Our ref: SX/2008/103545/01-L01
Your ref: BE/1/08
Date: 01 February 2008

OUTLINE APPLICATION FOR MIXED USE EMPLOYMENT (CLASS B1 HIGH QUALITY BUSINESS PARK COMPRISING UP TO 19,500 SQM GROSS FLOORSPACE) AND RETAIL (CLASS A1 GROCERY STORE UP TO 4,459 SQM NET SALES AREA) TOGETHER WITH PARKING, NEW HIGHWAY & ASSOCIATED SERVICING, INFRASTRUCTURE & LANDSCAPING - LAND AT OLDLANDS FARM, SHRIPNEY ROAD, BOGNOR REGIS

I can confirm that we object to this application as submitted. This objection is based on two reasons:

TITLE
Oldlands Farm Business Park
Bognor Regis
Parameters Assesment Plan

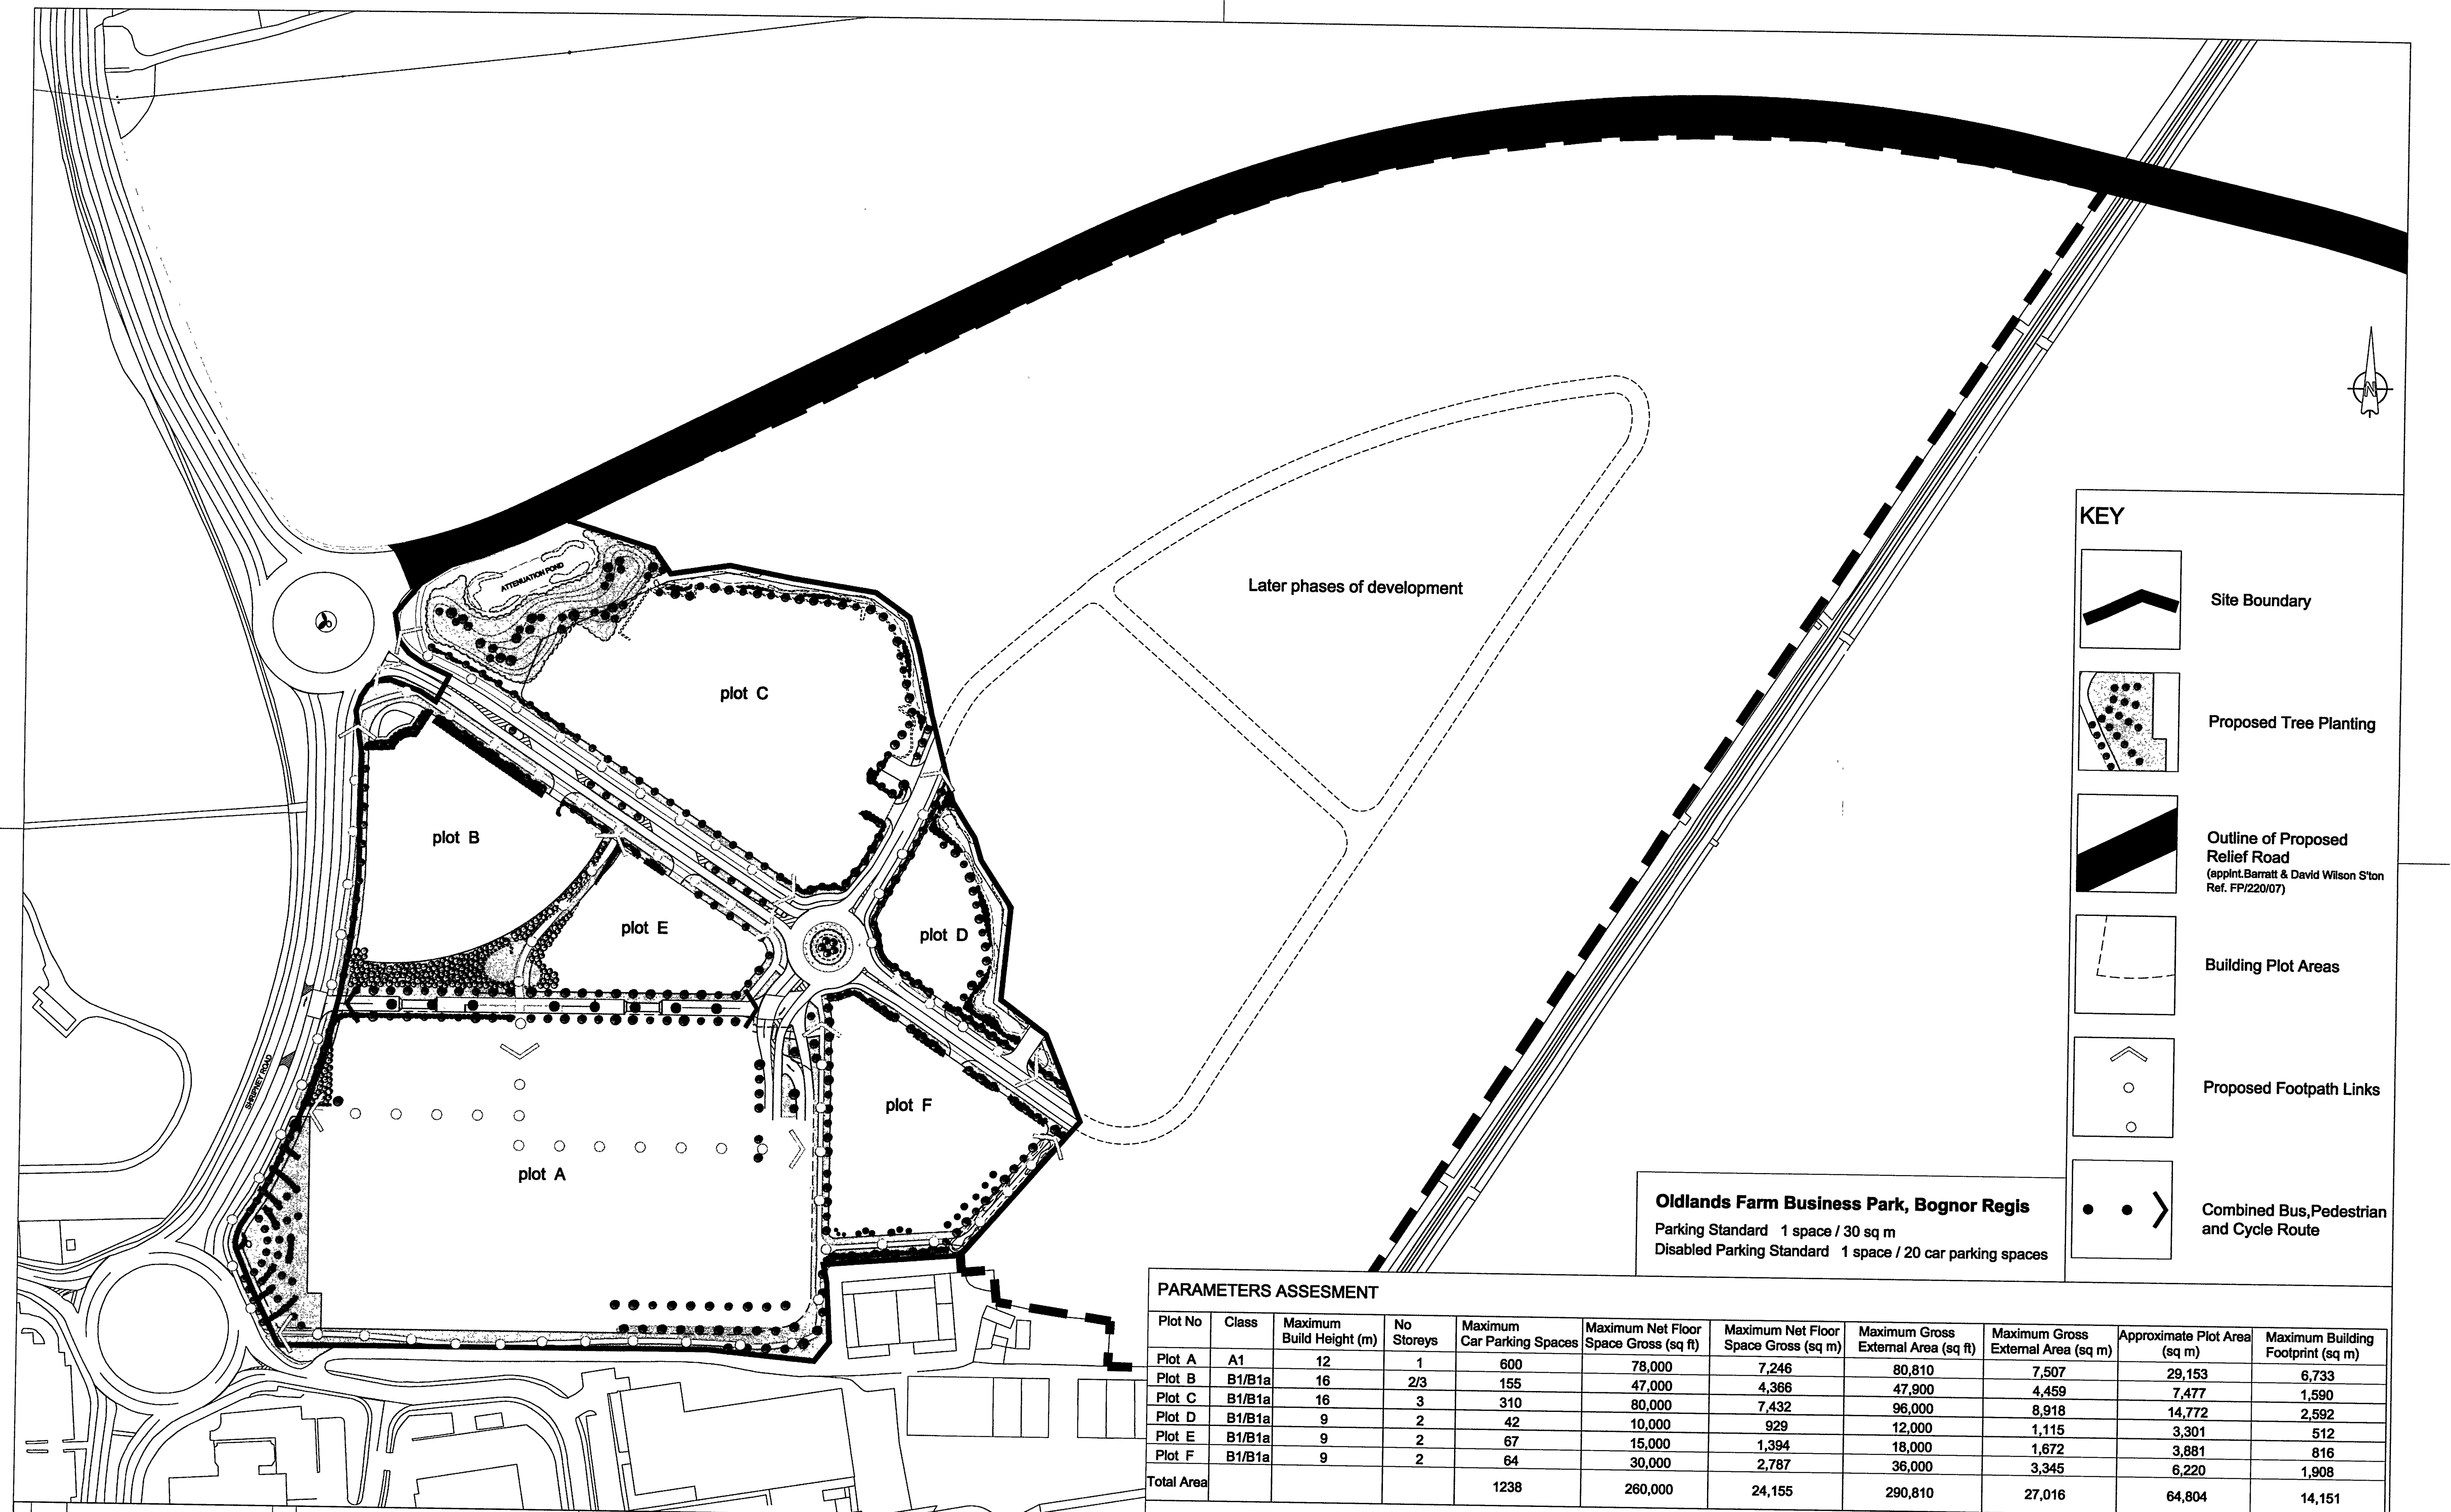
The application as submitted provides insufficient detail of surface water drainage storage and disposal. In the absence of these details we are unable to be certain that sufficient surface water storage is available in the areas shown on the plans as set aside for this purpose. As a result the application does not demonstrate that the flood risks resulting from this development can be safely managed.

On receipt of further information demonstrating that the surface water drainage from the site would not exacerbate flood risk we would be able to progress the removal of this objection. In particular we would require clarification of the following:

- Whether the surface water discharge point will be within the planning application red line boundary;
- Calculations, long sections or cross sections to confirm the storage volumes proposed. These should be based on a topographic survey;
- The Flood Risk Assessment (FRA) proposes that the minimum level at which surface water would be stored is 0.8m AOD. The FRA notes that the 100 year plus 20% climate change allowance flood level in the Lidsey Rife was estimated by WSP at 1.82m AOD. We are concerned that the water level in the local watercourse could be higher than 0.8m AOD. This would need to be clarified in order to calculate the available storage volume.
